technical memo

LOT 2 COPELAND CLOSE HORSLEY DRIVE BUSINESS PARK

In response to the Department's (TfNSW) correspondence dated 19 July 2016, the following is offered...

02 B-DOUBLE TURNING DIAGRAM 02
1:500 @ B1

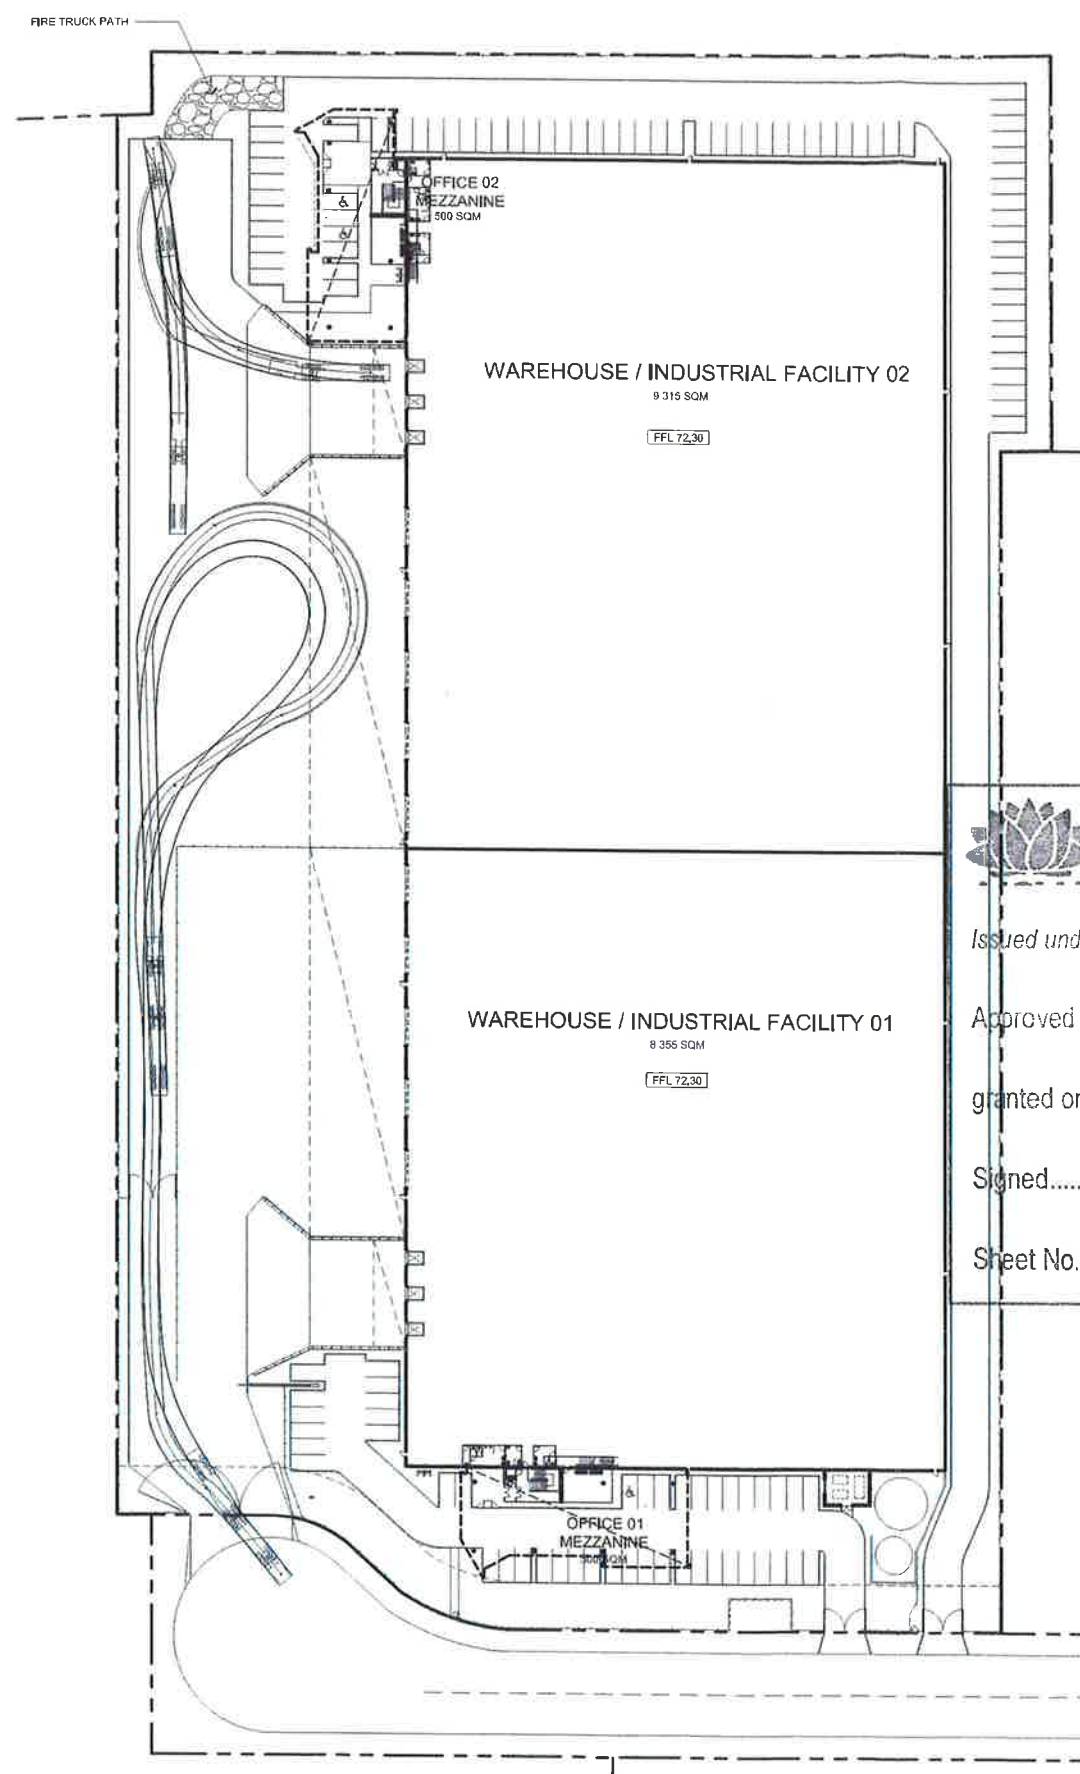
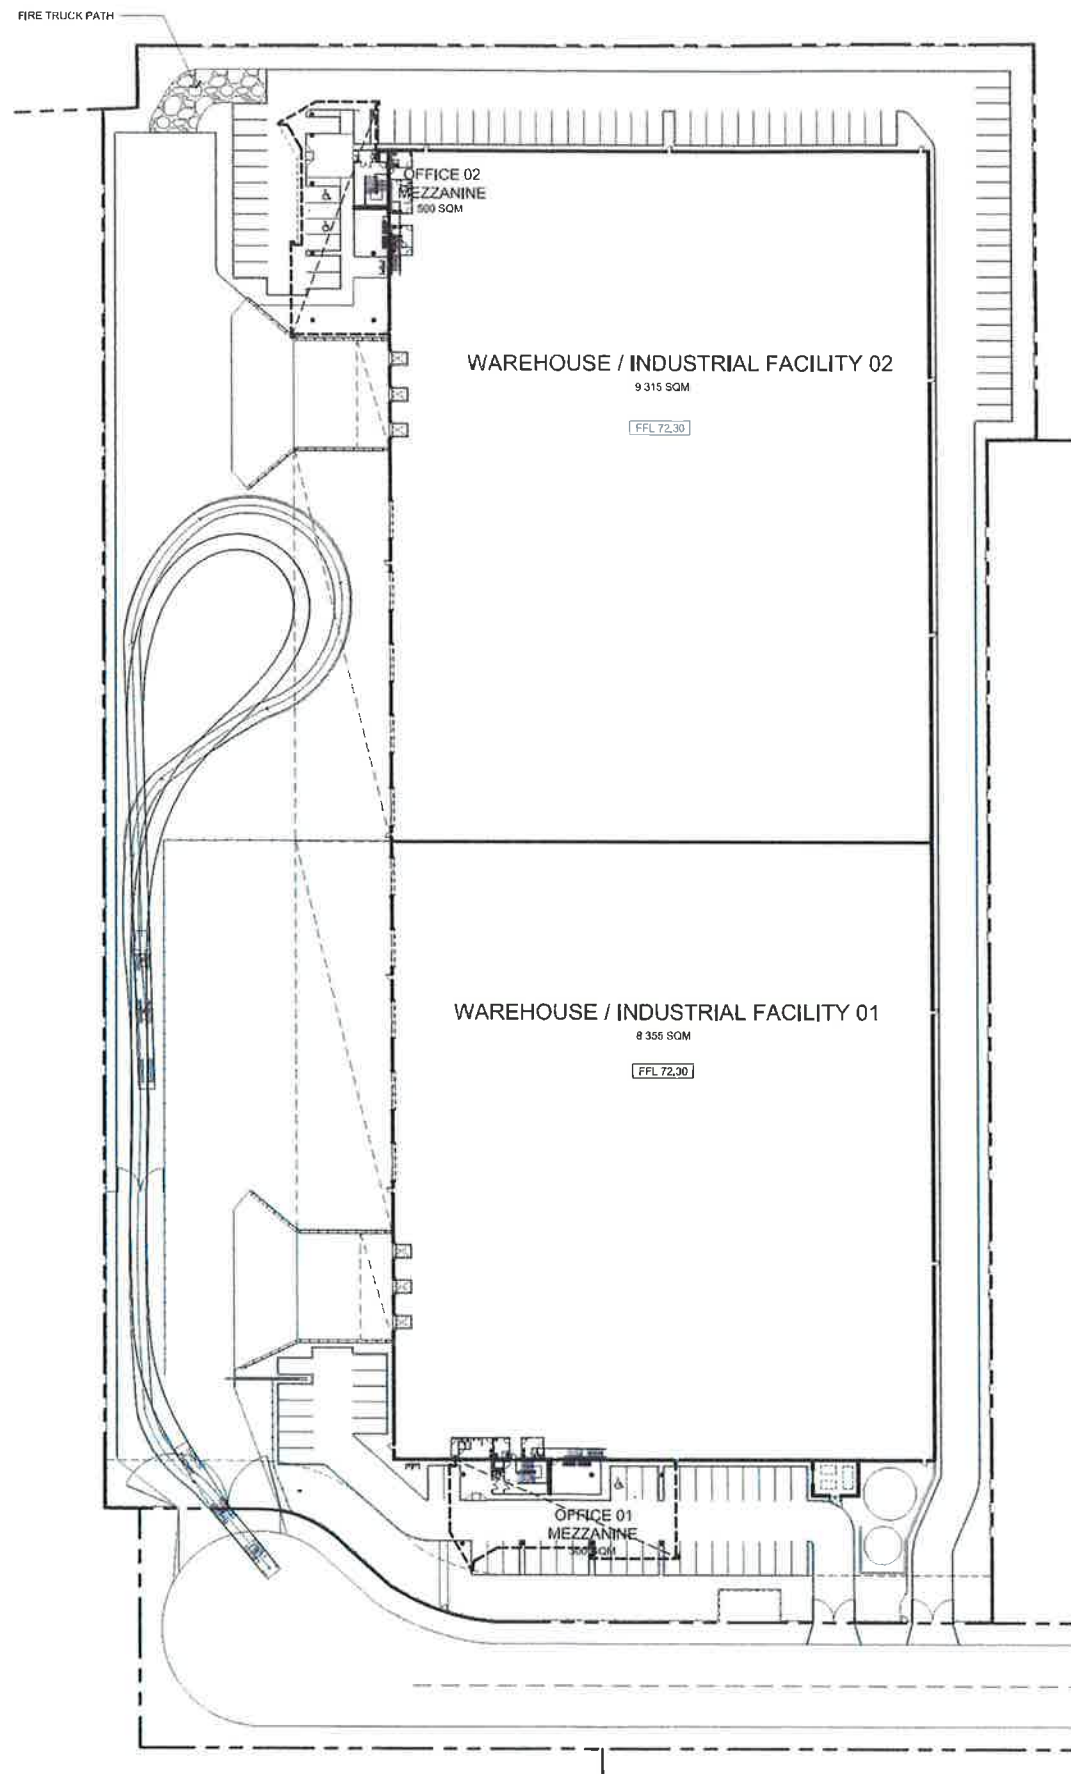
1. The proximity of the industrial facility site to the State Road Network has been noted. However, it is not the intention of the occupier of the site to employ the use of High Productivity Vehicles (HPV) but rather B-Doubles on a daily basis. Therefore, a Level 2B PBS Vehicle turning path is inappropriate for the site.

2. The adopted design vehicle for the site is a B-Double which will not engage in decoupling but employ side loading in close proximity to the loading docks, as outlined in the Loading Dock Management Plan, accompanying the Development Application (DA).
